From: Julia Davies [REDACTED]
Sent: 18 October 2018 12:17
To: Planning
Subject: Little Glebe, Fontwell (AL/111/18/HH)

Further to your emailed letter dated 11th October, please find attached copies of revised drawings P01a, P03a and P04a, together with new drawing P05.

Proposed Extension and Alterations
at Little Glebe, Little Heath Road, Fontwell
for Mr and Mrs R Lynes
Drawing P03a September 2018 Scale 1:100 @ A2
Planning Drawing - Second Floor Plan & E & W Elevations

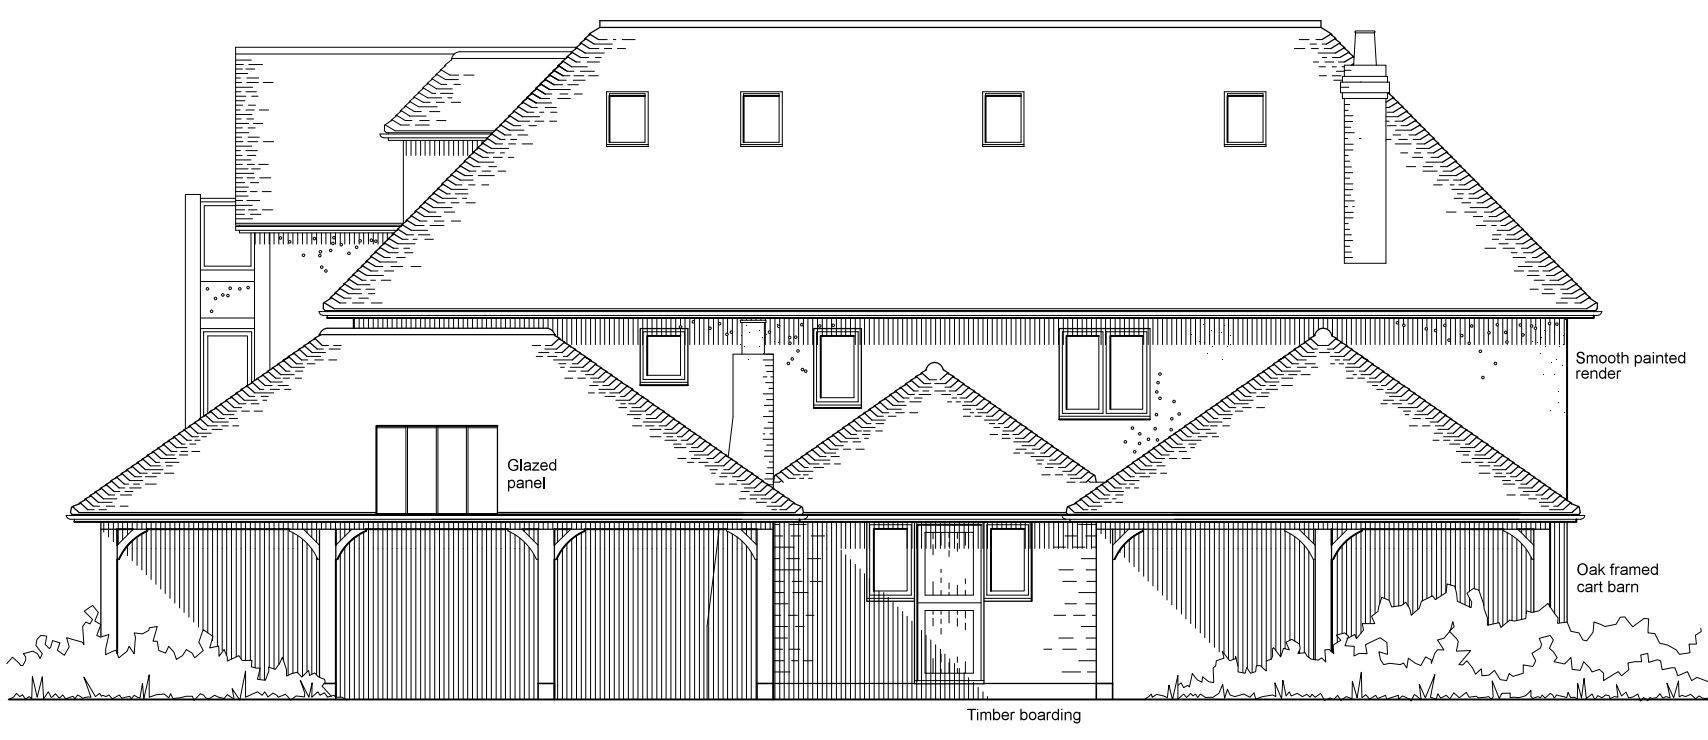
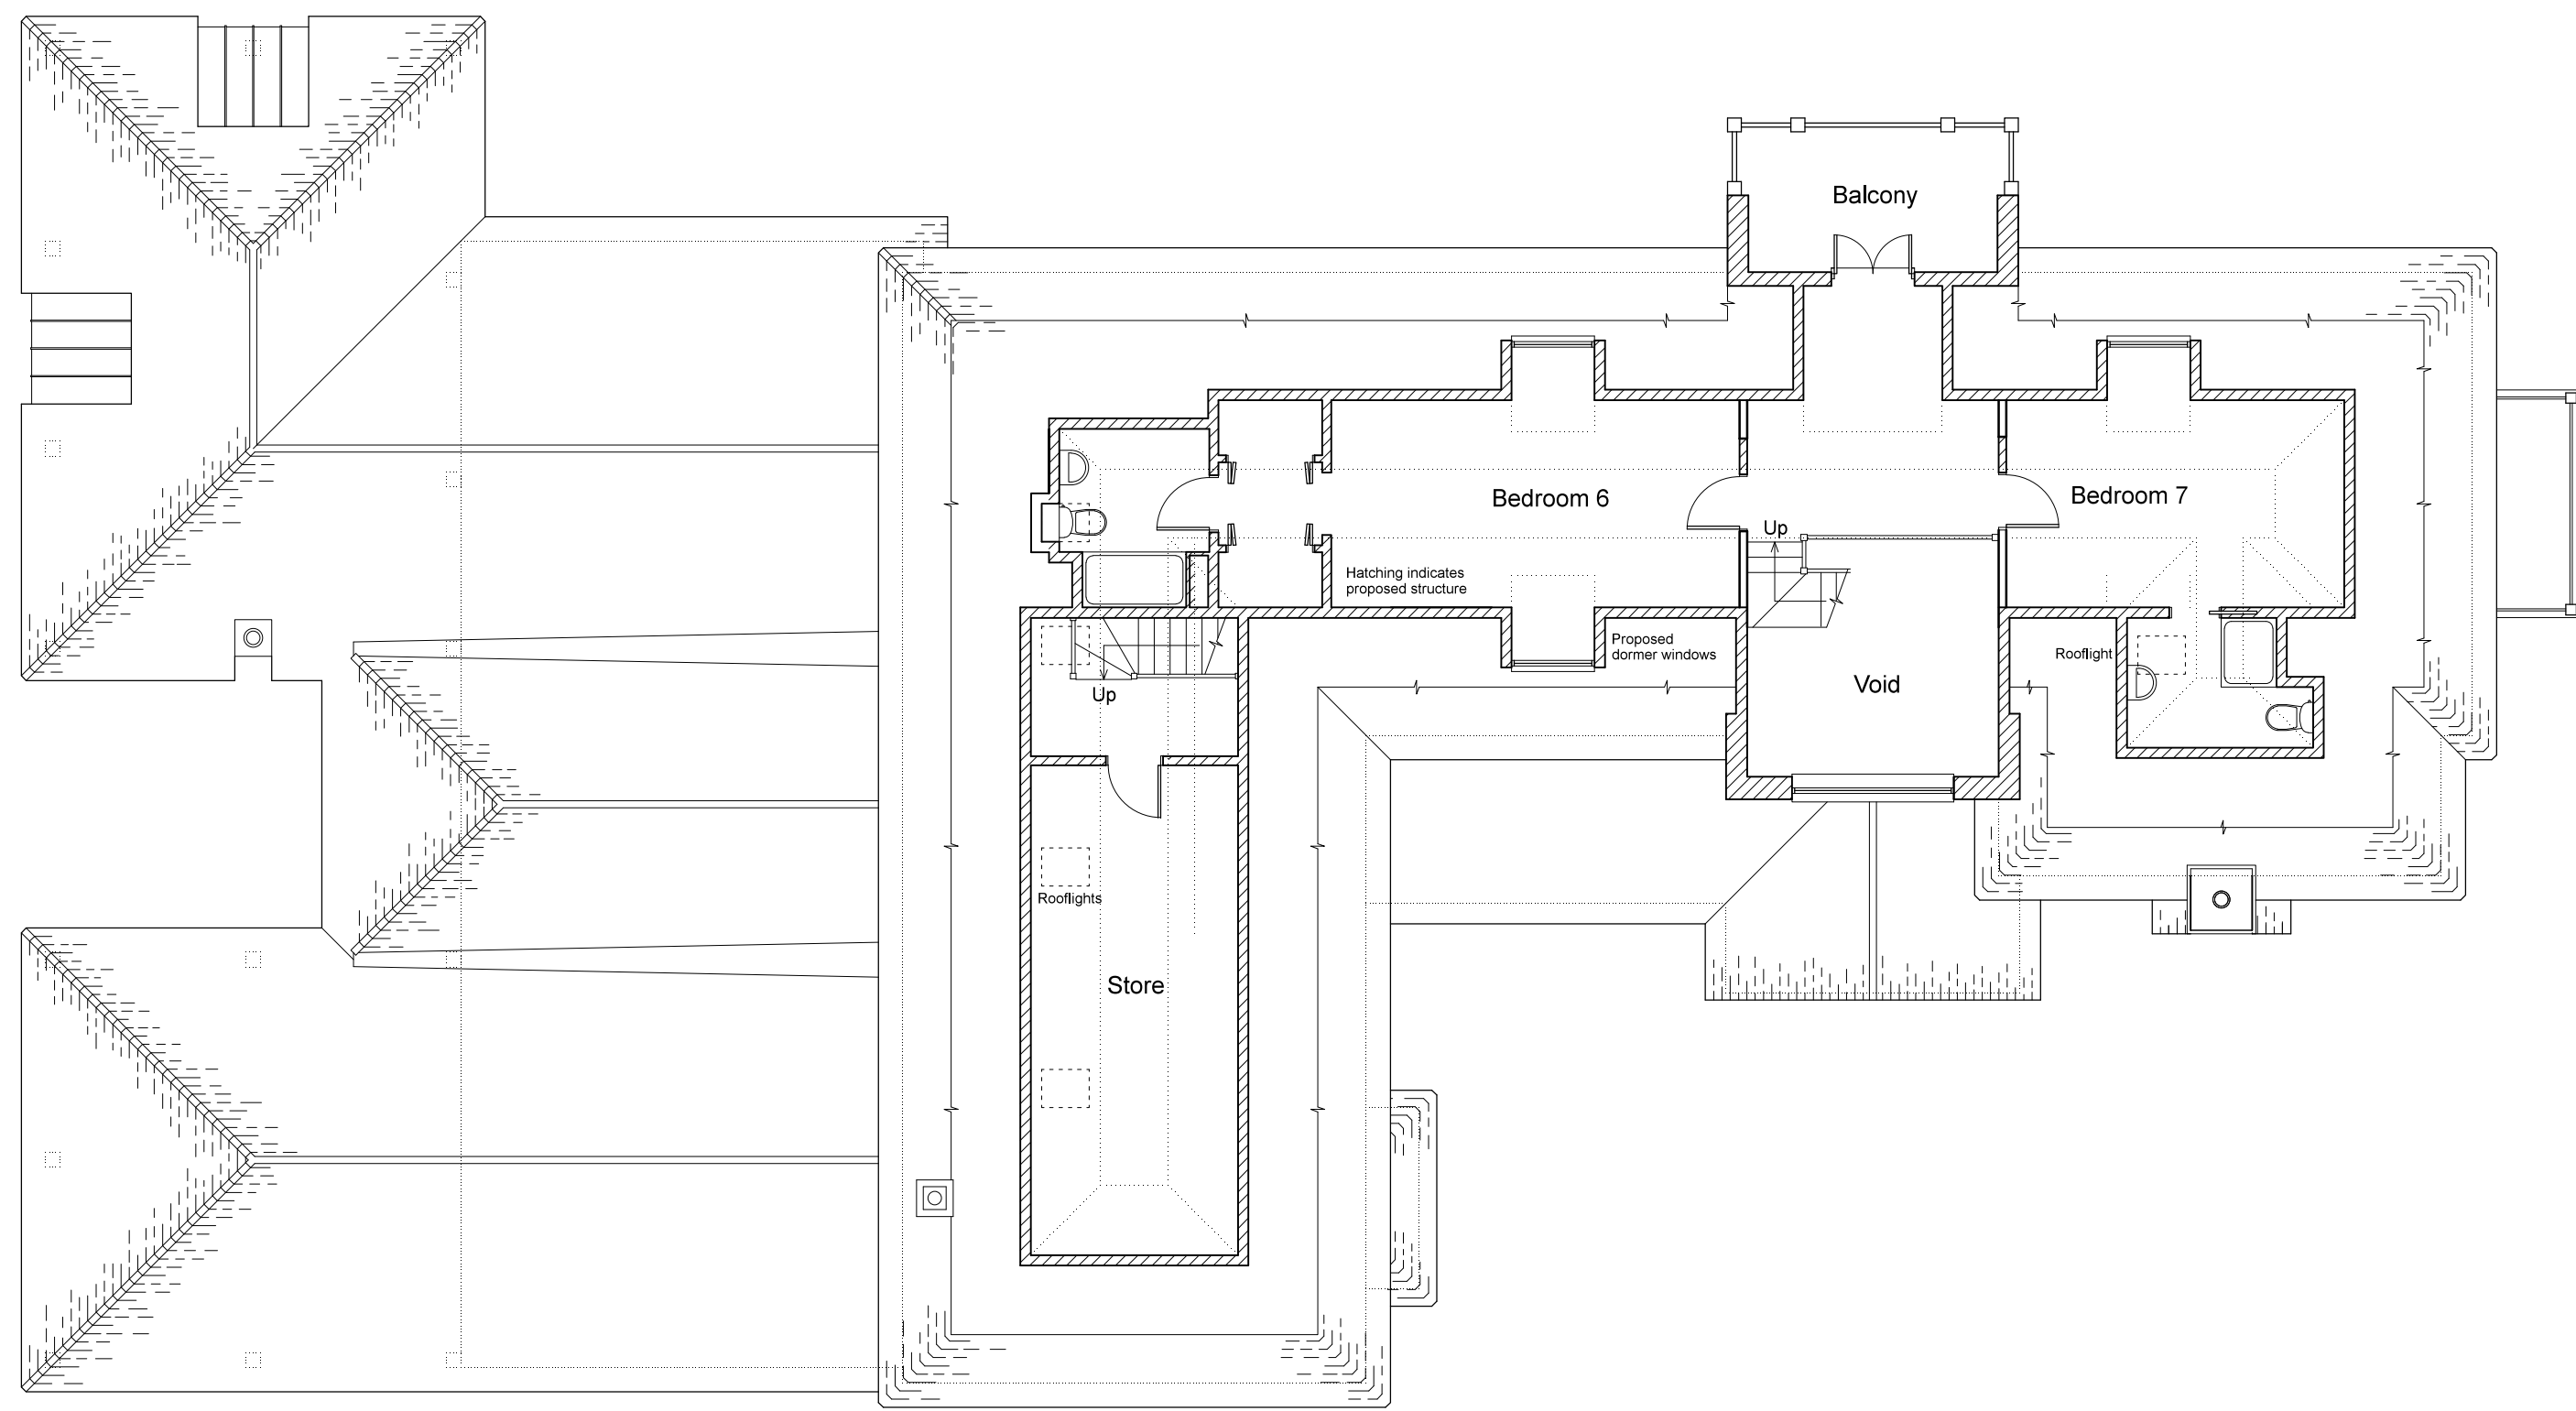
Plans

Drawings P01a, P03a and P04a have been revised to show the correct roof configuration and omitted window on the west elevation.
